CITY OF ALBUQUERQUE

February 20, 2025

Re: Albuquerque Christian Children's Home Cottage #4
5700 Winter Haven Rd NW
Traffic Circulation Layout
Engineer's/Architect's Stamp x-x-x (E12D005)

A1  
TCL 1  
SITE PLAN

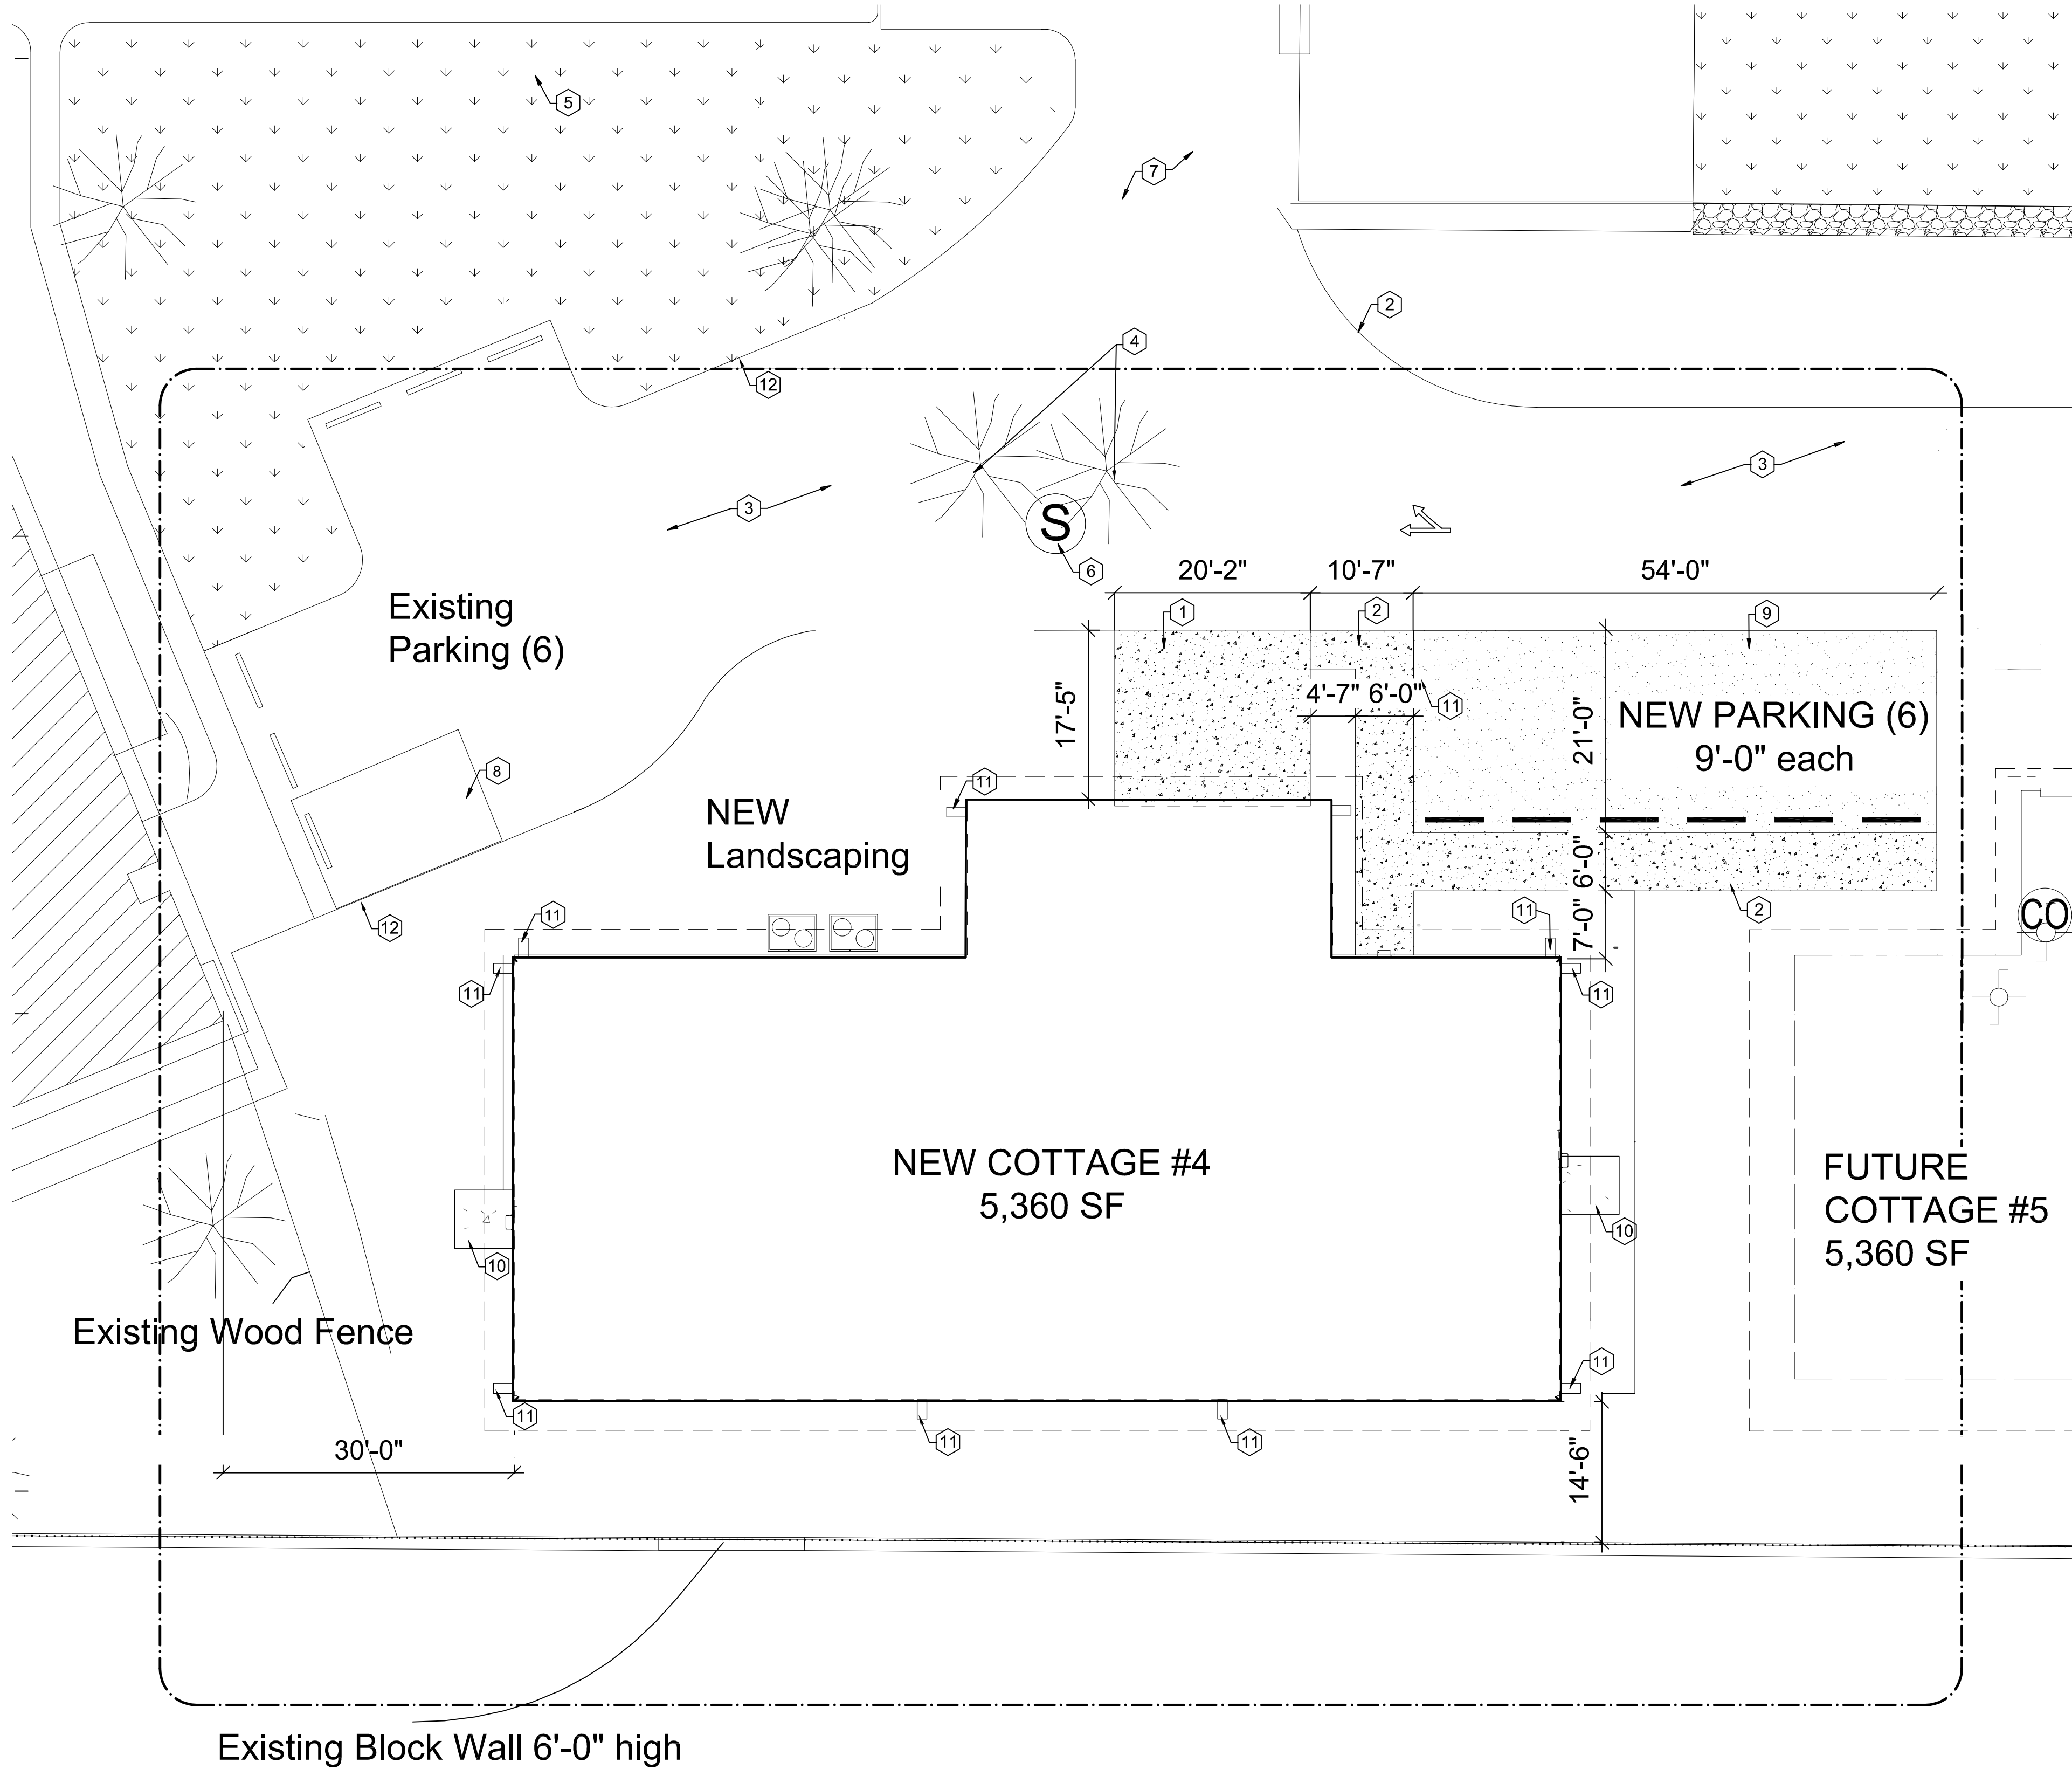
1. The traffic circulation layout must be stamped, signed, and dated by an engineer or architect licensed in the state of New Mexico.
2. The existing parking area geometry is not allowed, please rearrange this area for a safer parking.
